RE PLANNING APPLICATION EP/144/13/

Please find enclosed a list of our comments on the extension proposed by our neighbours Jason and Rebecca Hazzard at 91 North Lane, East Preston.

Below are our comments on the proposals for extending 91 North Lane. We are the owners and residents of the adjacent property at 93 North Lane. We wish to register an objection to the scale and to the positioning of the proposed extension on the following grounds:

Block Plan
Garage Proposals
Planning Issue

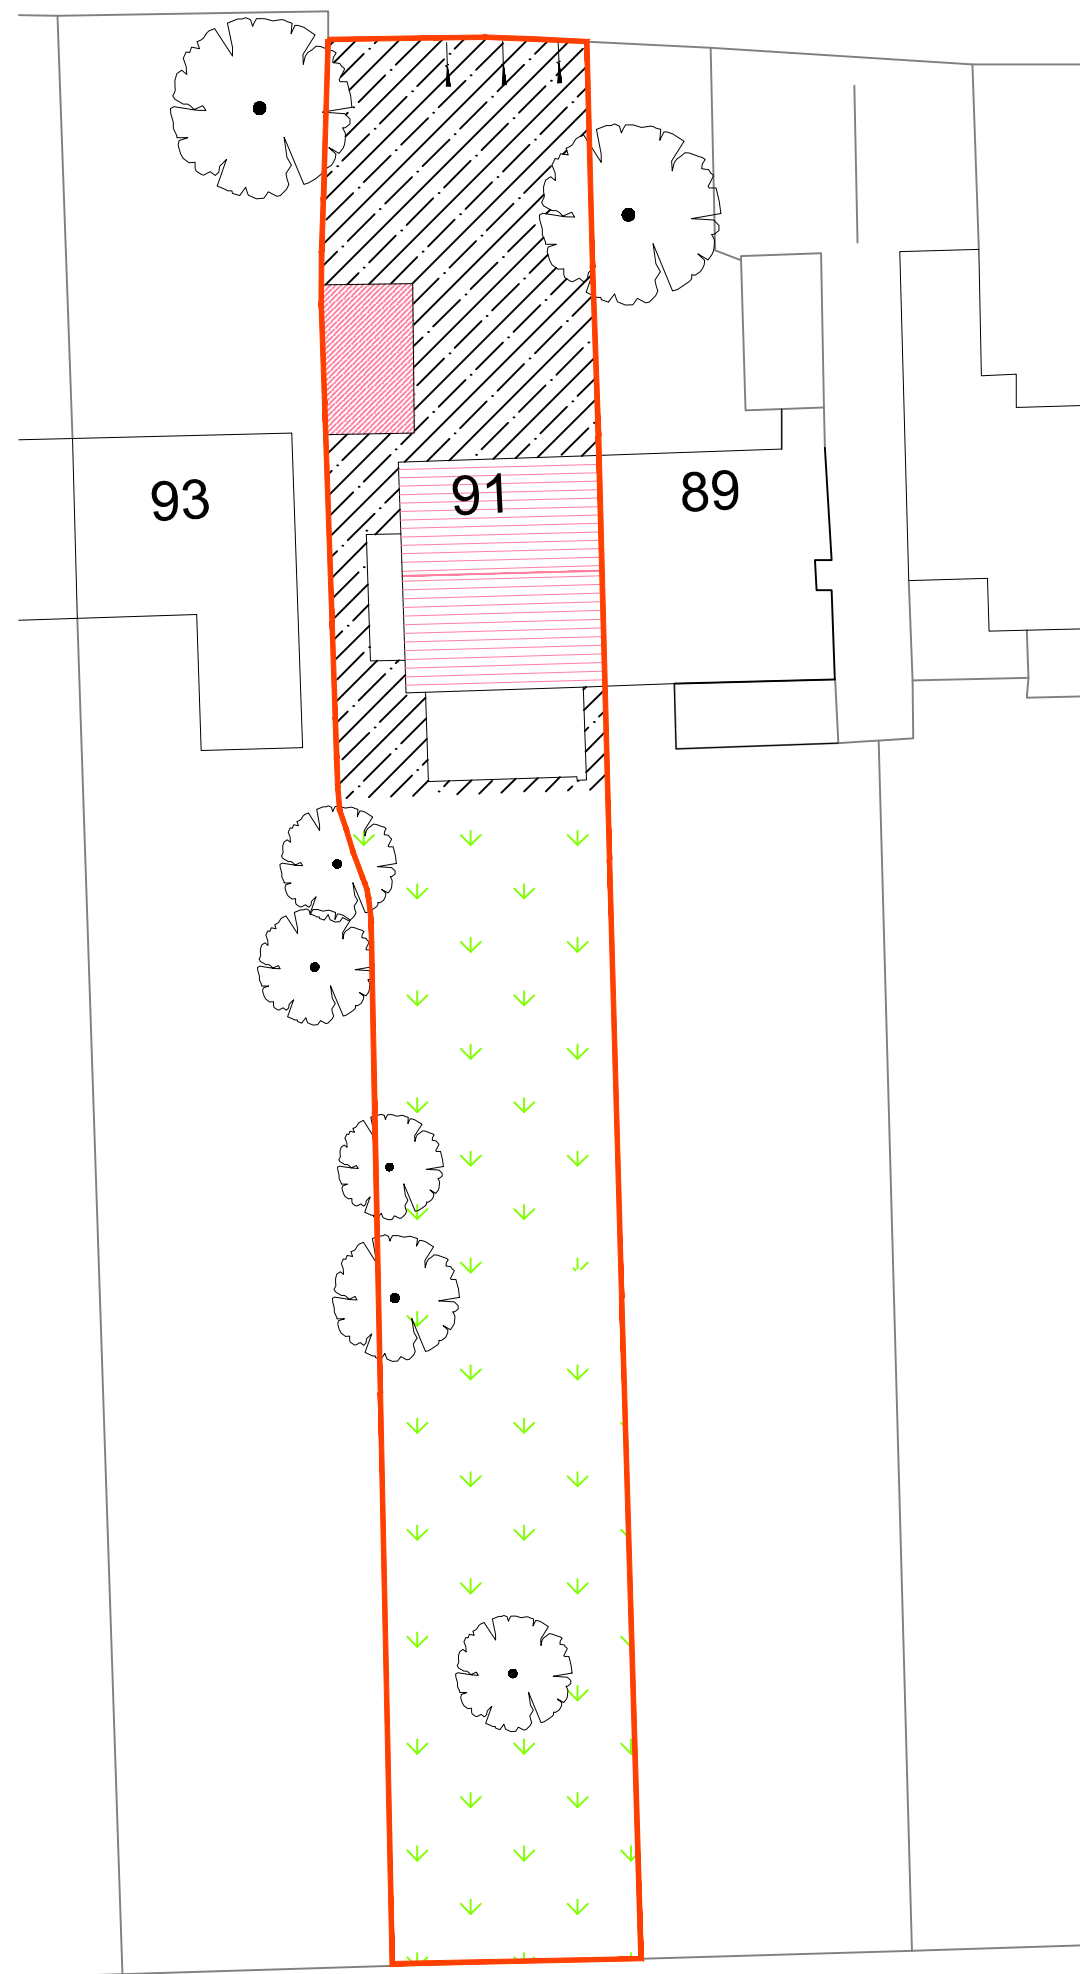
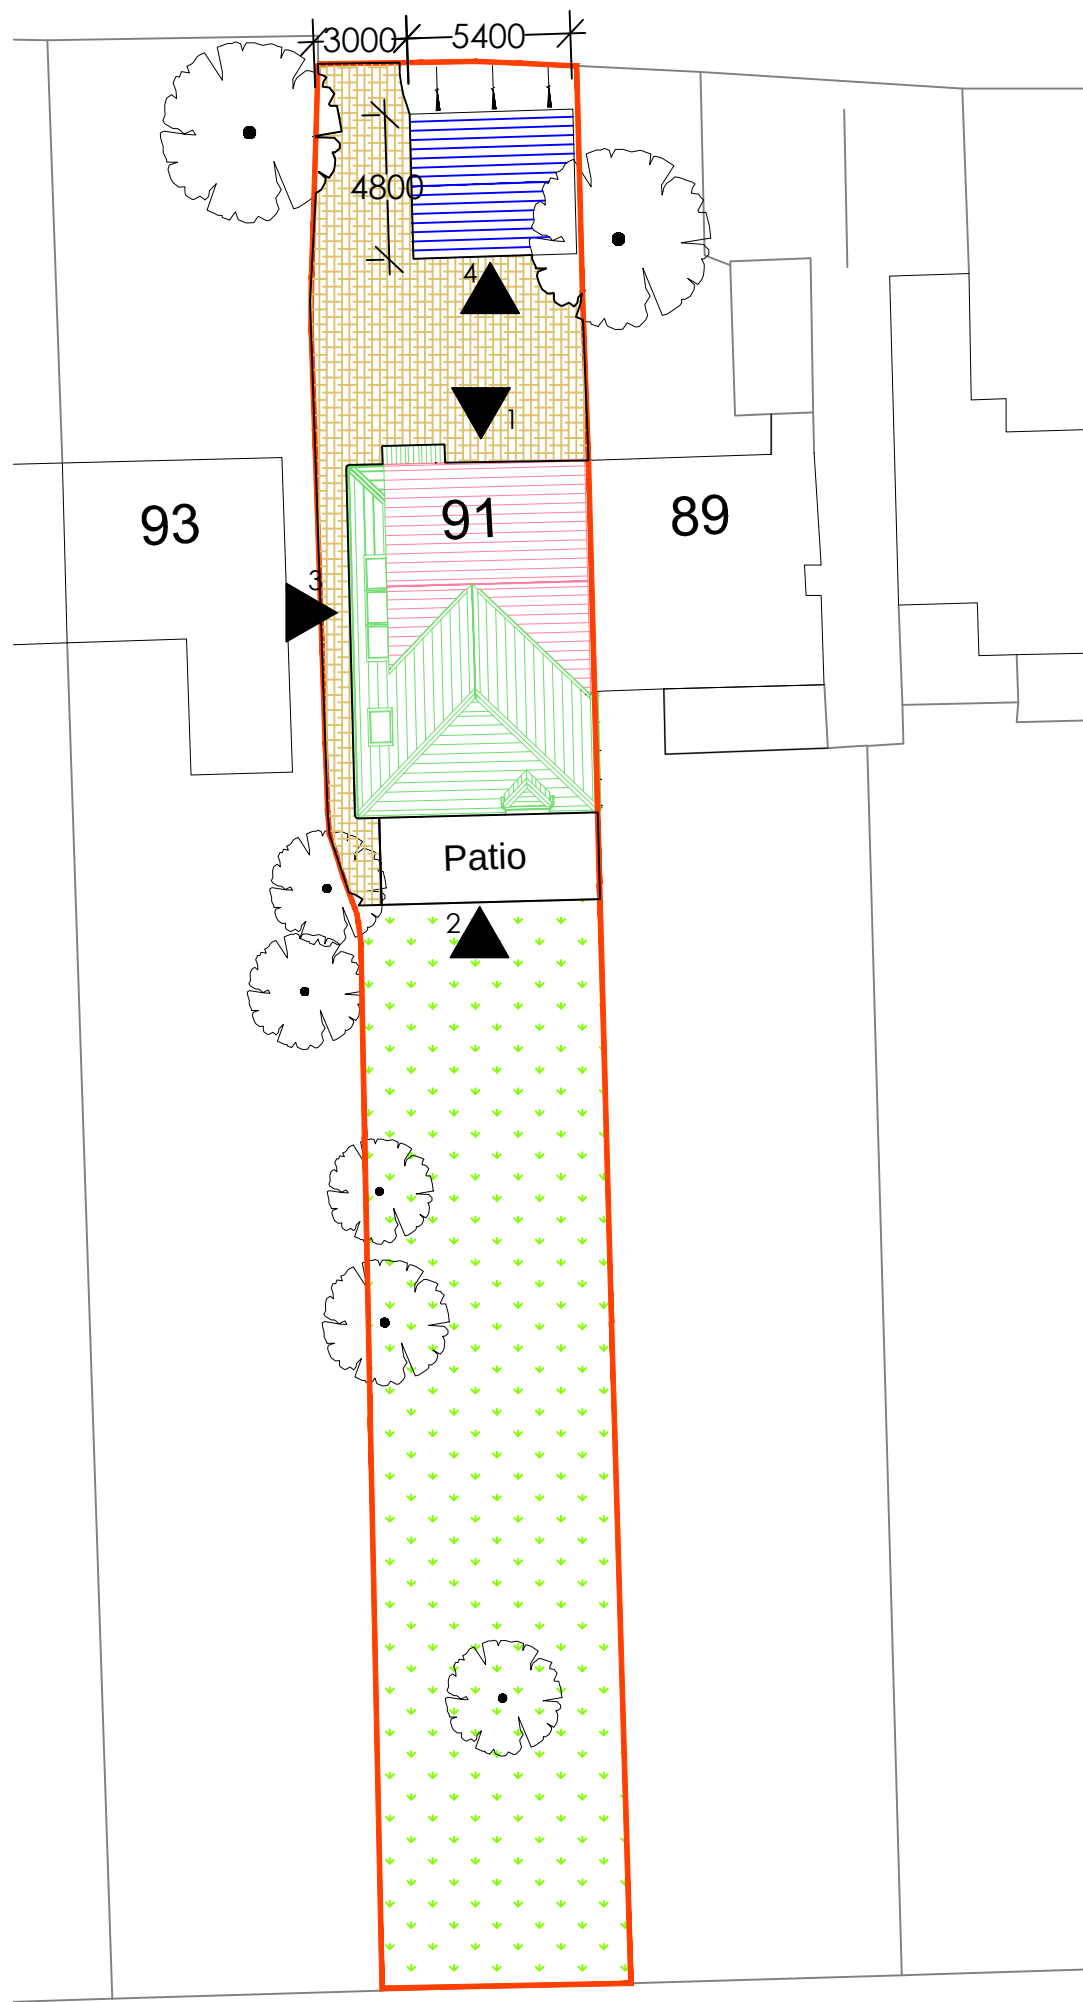
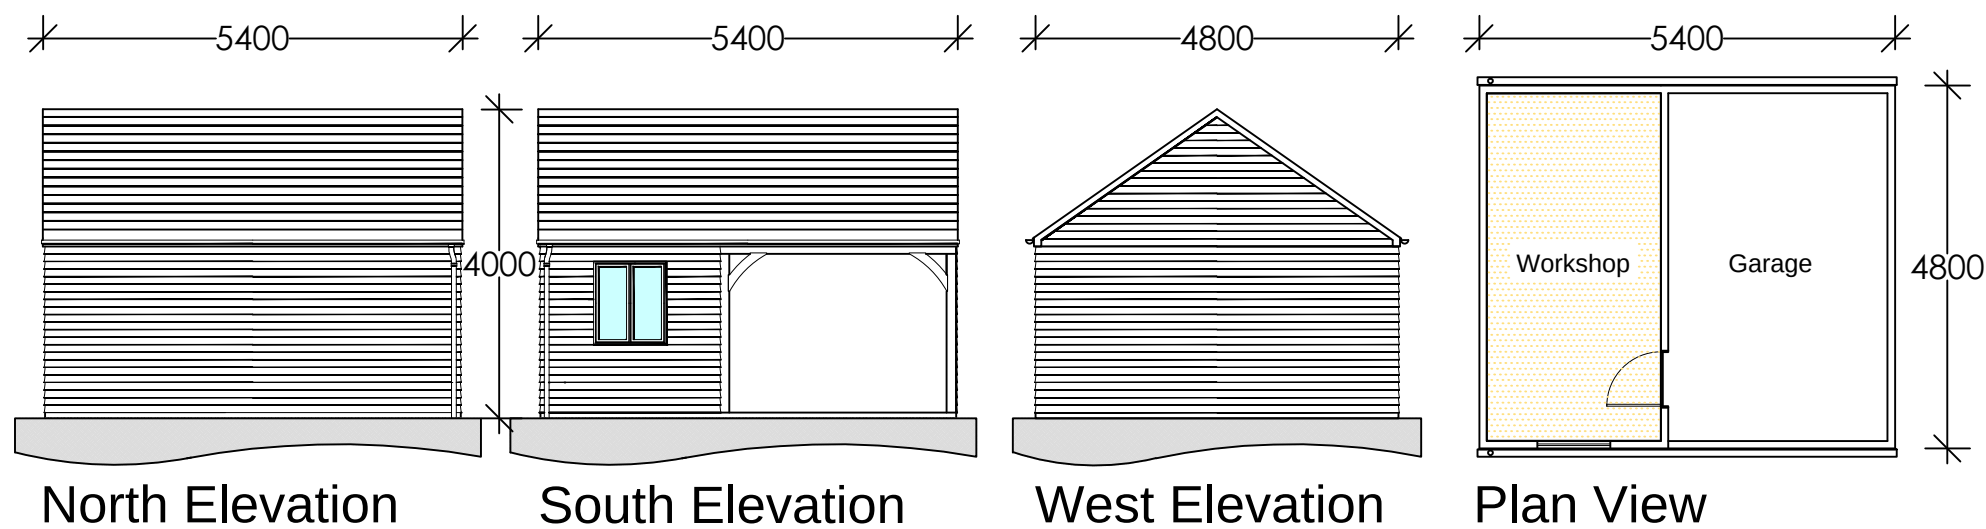
The extent of the development in a southerly direction would increase these factors and would create a tunnel-like sensation on the east side of our house. The proposed close proximity of the new structure is potentially threatening to the footing of our house. According to the <i>Party Wall Act 1996</i>, we are entitled to receive protection from any possible damage. As the bathroom of the proposed property would be on the west side, we also have serious concerns regarding the installation of drains in the narrow space available between the houses, bringing with it the potential for damage to our drains which are located on the same side. We are informed by the owners that the proposed extension along the west wall of number 91 will be a timber-framed construction; because of the close proximity, less than a metre from our party wall, there would be a potential fire risk.

▪	<i>Character of the neighbourhood</i> We observe from the plans that the proposed extension would increase the volume of number 91 by more than a third. We believe that this may contravene local planning policy. The properties 89, 91, 93 and 95 North Lane form a group of modestly proportioned cottages which contribute significantly to the character of this area of the village. The proposed extension to number 91 would alter the harmoniousness of this grouping.

DRAWING
West Facing (Side Elevation)
Location Plan/ Block Ref
Planning Issue

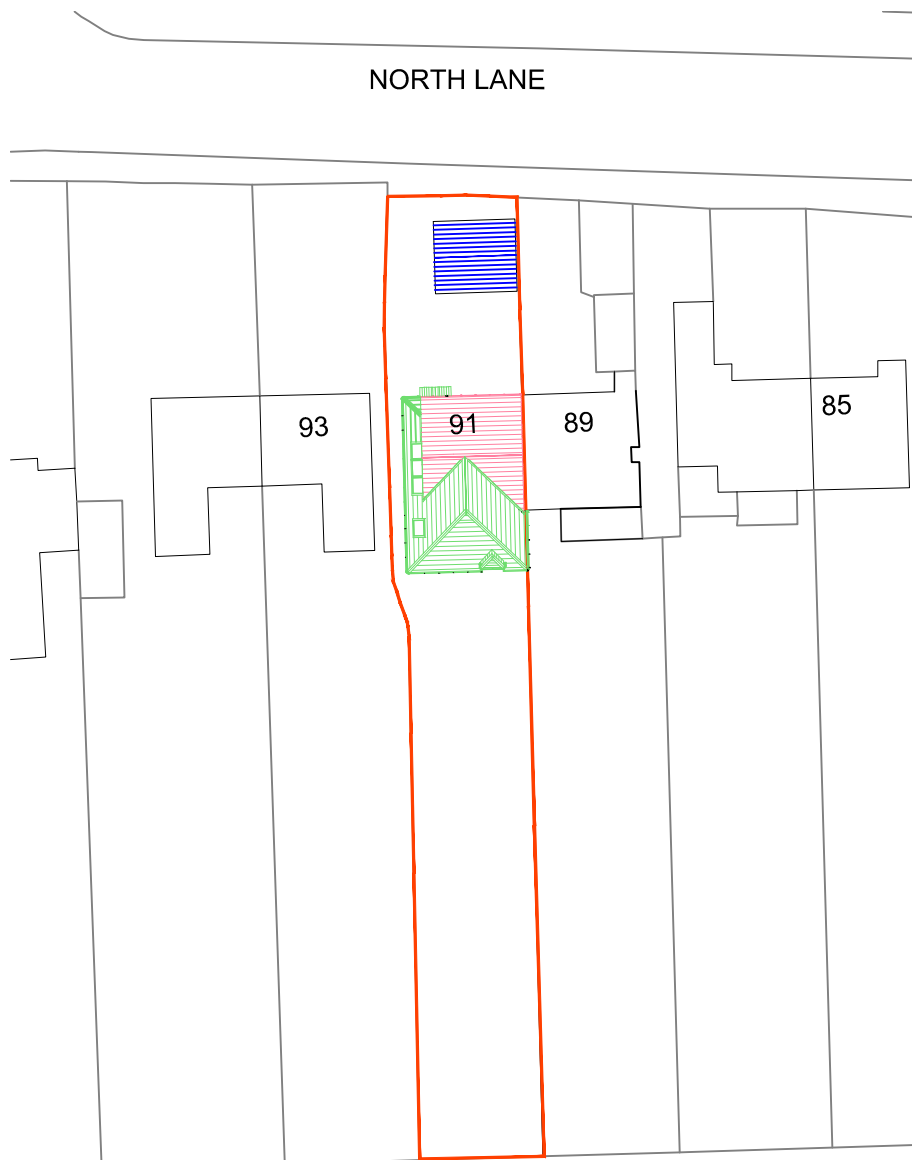
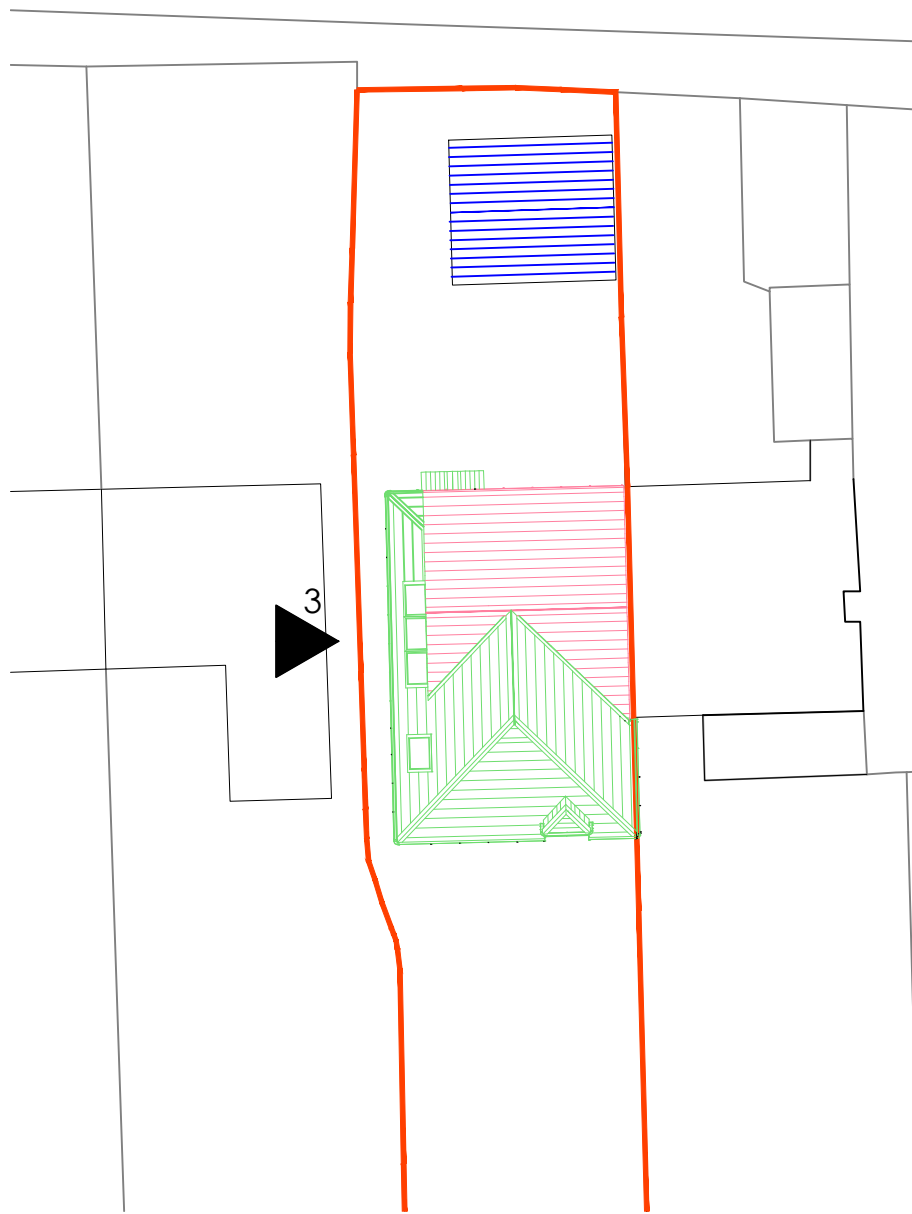
■	<i>Overshadowing</i> We note that the design of the extension has taken no account of the fact that there are three windows on the adjacent face of our property. The proposed extension would adversely affect the light in three primary rooms of our house: the hall on the ground floor and the two east-facing bedrooms on the first floor. For a substantial part of the morning the sun would be cut off behind the southern reach of the extension and the proximity and scale of the extension would affect light throughout the day. These rooms have no source of light other than our east windows; there are no windows on our north face, so that the lightness of a large portion of our house would be severely affected. We understand that <i>Right of Light</i> is protected under common law and by the <i>Prescription Act of 1832</i>: as all three windows on the east side of the house are more than twenty years old, they fall within the remit of these regulations. The light is already compromised on that side by the existing building; the proposed extension would present a serious obstruction, because of its proximity, length and height. As we believe that the extension would breach the 25 degree rule, as laid out in the <i>Building Research Establishment (BRE) document 'Site Layout Planning for Daylight and Sunlight: A guide to good practice'</i>, we would if necessary consider requesting a Local Authority survey to measure the impact of the proposals. We also believe that light into our south-facing windows would be affected by the height and length of the southerly extension, in contravention of the 45 degree rule (BRE document).

■	<i>Overbearingness</i> Because of the scale of the proposed two-storey development along the west wall of number 91 and because of its very close proximity to our property, our path and entrance would feel constricted. The sensation looking out from our hall and from our two east-facing bedrooms would be one of claustrophobia. The proposed two-storey development would extend further south than the wing of our house; it would be evident to us in our ground floor kitchen and our first floor bathroom. It would overlook and alter the character of our garden.
■	<i>Proximity</i> The proposed extension would come within less than one metre of our party fence wall, in what is already a narrow corridor between the two properties. For the reasons outlined above, this close proximity would affect both the light and the atmosphere of our property.
